From: Laura Gibbons <Laura.Gibbons@arun.gov.uk>
Sent: 22 March 2022 12:25
To: Planning.Responses <Planning.Responses@arun.gov.uk>
Cc: Claire Potts <Claire.Potts@arun.gov.uk>
Subject: RE: Notification of an Environmental Statement BN/11/22/OUT

Engineers Comments Regarding Surface Water Drainage

Application No: BN/11/22/OUT
Registered: 4th February 2022
Site Address: Barnham, Eastergate, Westergate BEW Parcel SC1 Barnham
Grid Reference: 494830 104610
Category:
Description of Works: Outline application with all matters reserved (except for the A29 Realignment) for the demolition of existing structures and mixed use development to provide residential dwellings (Use Class C3), Care Home/Senior Living Accommodation (Use Class E/F2/Sui Generis), a Primary School plus open space, landscaping, drainage and all other associated ancillary works; and realignment of the A29 and early connection to existing A29 including construction of a new road carriageway, junctions and associated infrastructure. This application also lies within the parish of Aldingbourne, affects the setting of listed buildings, affects the character & appearance of the Eastergate Church Lane Conservation Area and affect

Figure 2.1 Watercourse Location Plan including Site Observations

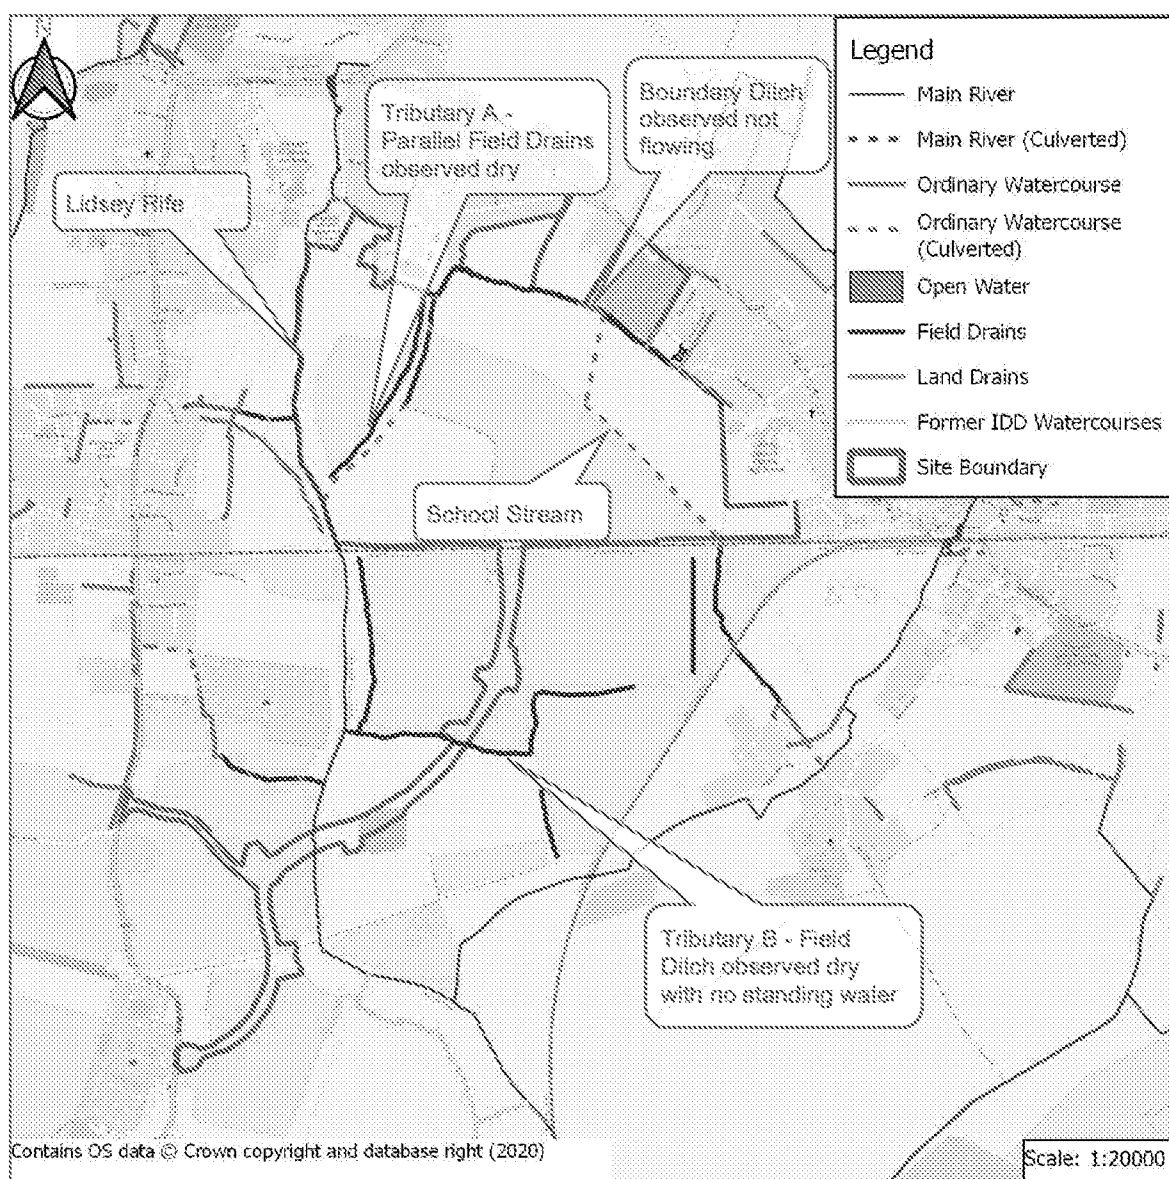
The proposals to de-culvert the school watercourse are acceptable in principle, but need fully detailed conversations between ourselves and the applicants engineers as proposals progress. We would also encourage the route of this

new open watercourse to be pulled slightly further away from the development periphery to ensure adequate room for maintenance along both sides of the watercourse and no detrimental impacts to adjacent landowners.

Figure 3.1 Groundwater Monitoring Locations

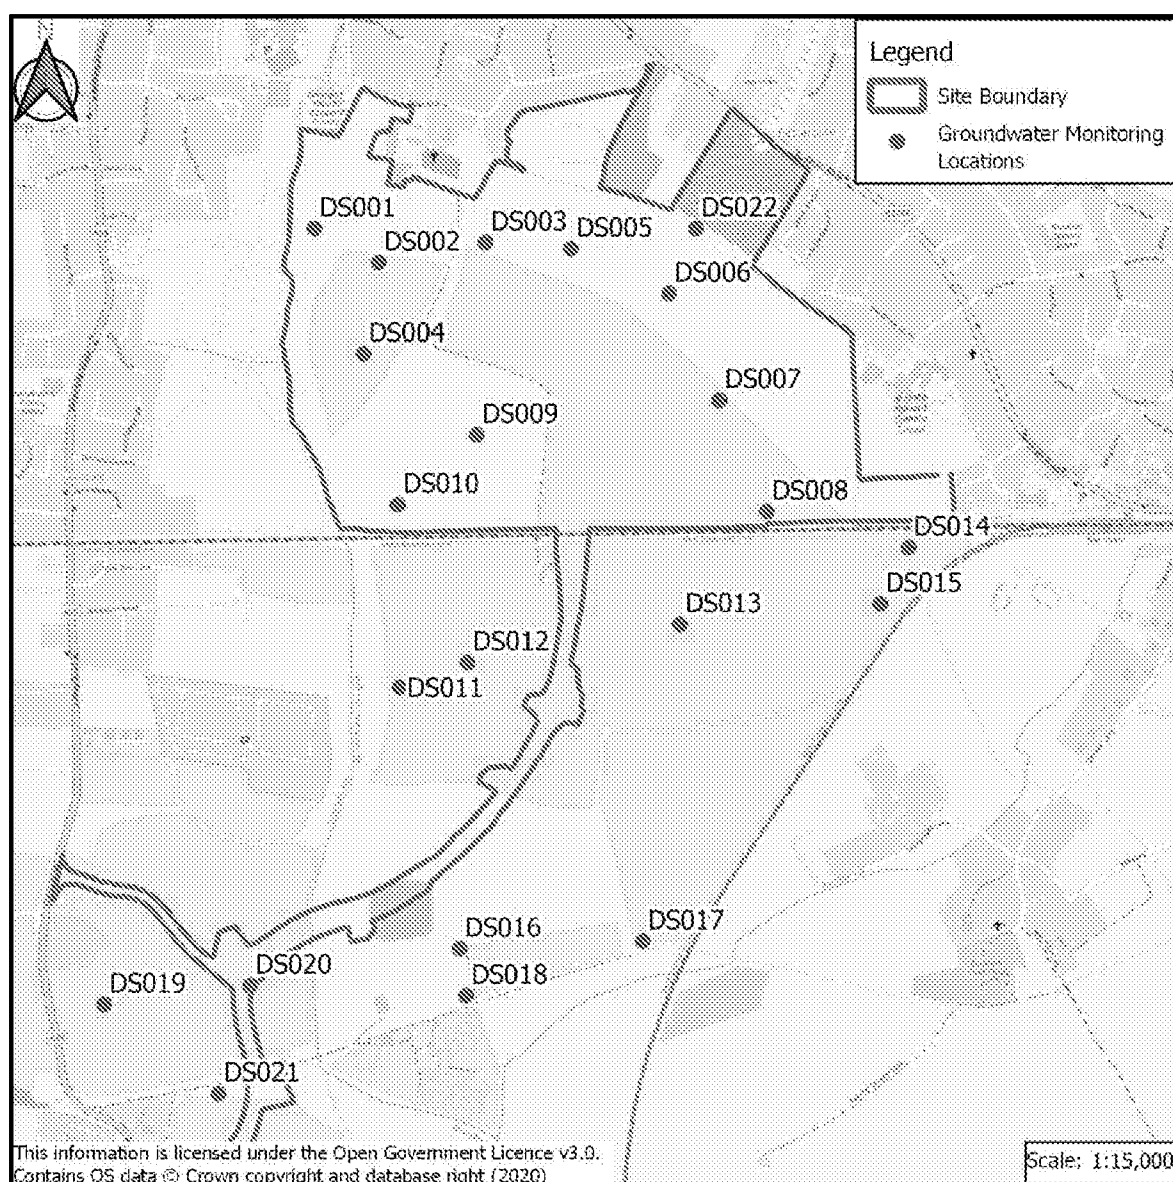
It is noted that groundwater monitoring has been completed, and has identified groundwater at relatively shallow depths. There are some parcels within the site where groundwater is slightly deeper, and shallow infiltration potential should be explored. We would expect more targeted monitoring to be completed at later stages to better identify the extents of these areas of deeper groundwater.
